Your Ref
BR/222/18/PL
Our Ref
PLAN-025192
Date
15/11/2018

Proposal: Erection of 4no. 2 bedroom dwellings with associated parking & landscape.

Site: Land adjacent to Community Centre Westloats Lane Bognor Regis, PO21 5JZ.
BR/222/18/PL

Drawing Title
Site Layout, Levels and Drainage

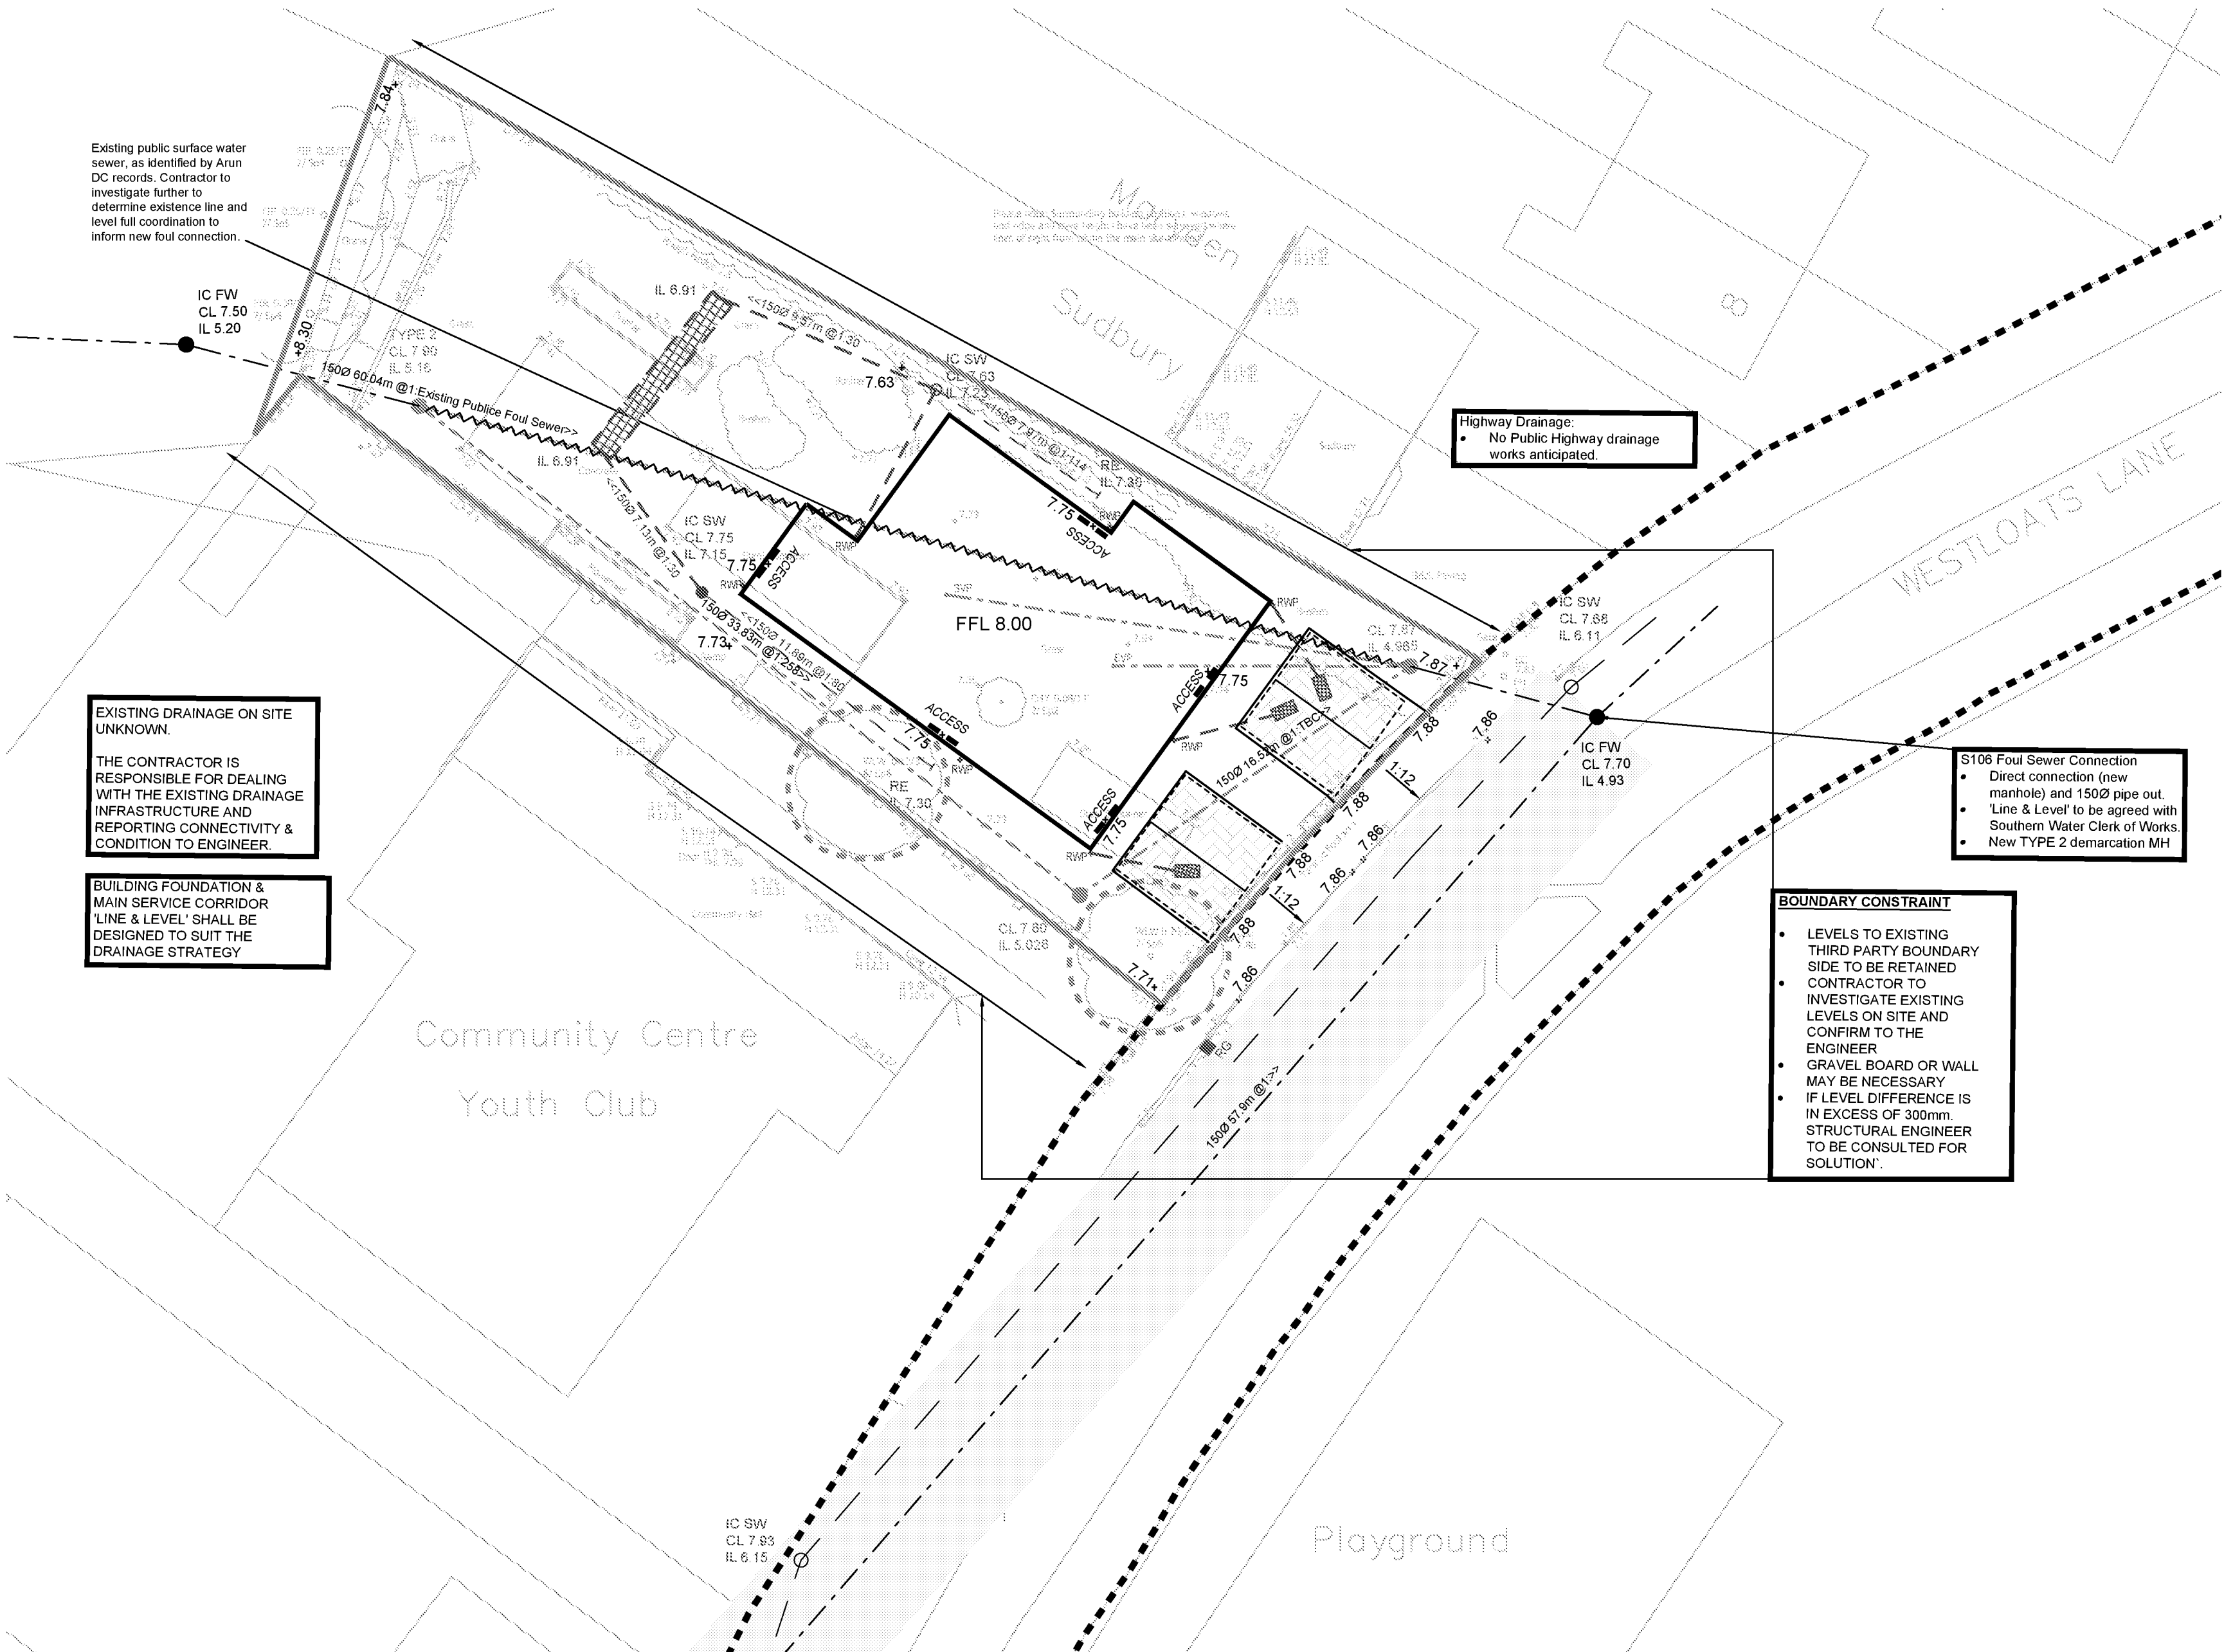
It appears that applicant is proposing to divert public sewer. Southern Water requests a formal application for sewer diversion under S185 of Water Industry Act 1991 in order to divert any public sewer.

No development or new tree planting should be located within 3 metres either side of the external edge of the public sewer and all existing infrastructure should be protected during the course of construction works.

No new soakaways, swales, ponds, watercourses or any other surface water retaining or conveying features should be located within 5 metres of a public gravity sewer.

In order to divert the drainage apparatus, Southern Water requests that if consent is granted, a condition is attached to the planning permission. For example "The developer must advise the local authority (in consultation with Southern Water) of the measures which will be undertaken to protect the public sewers, prior to the commencement of the development."
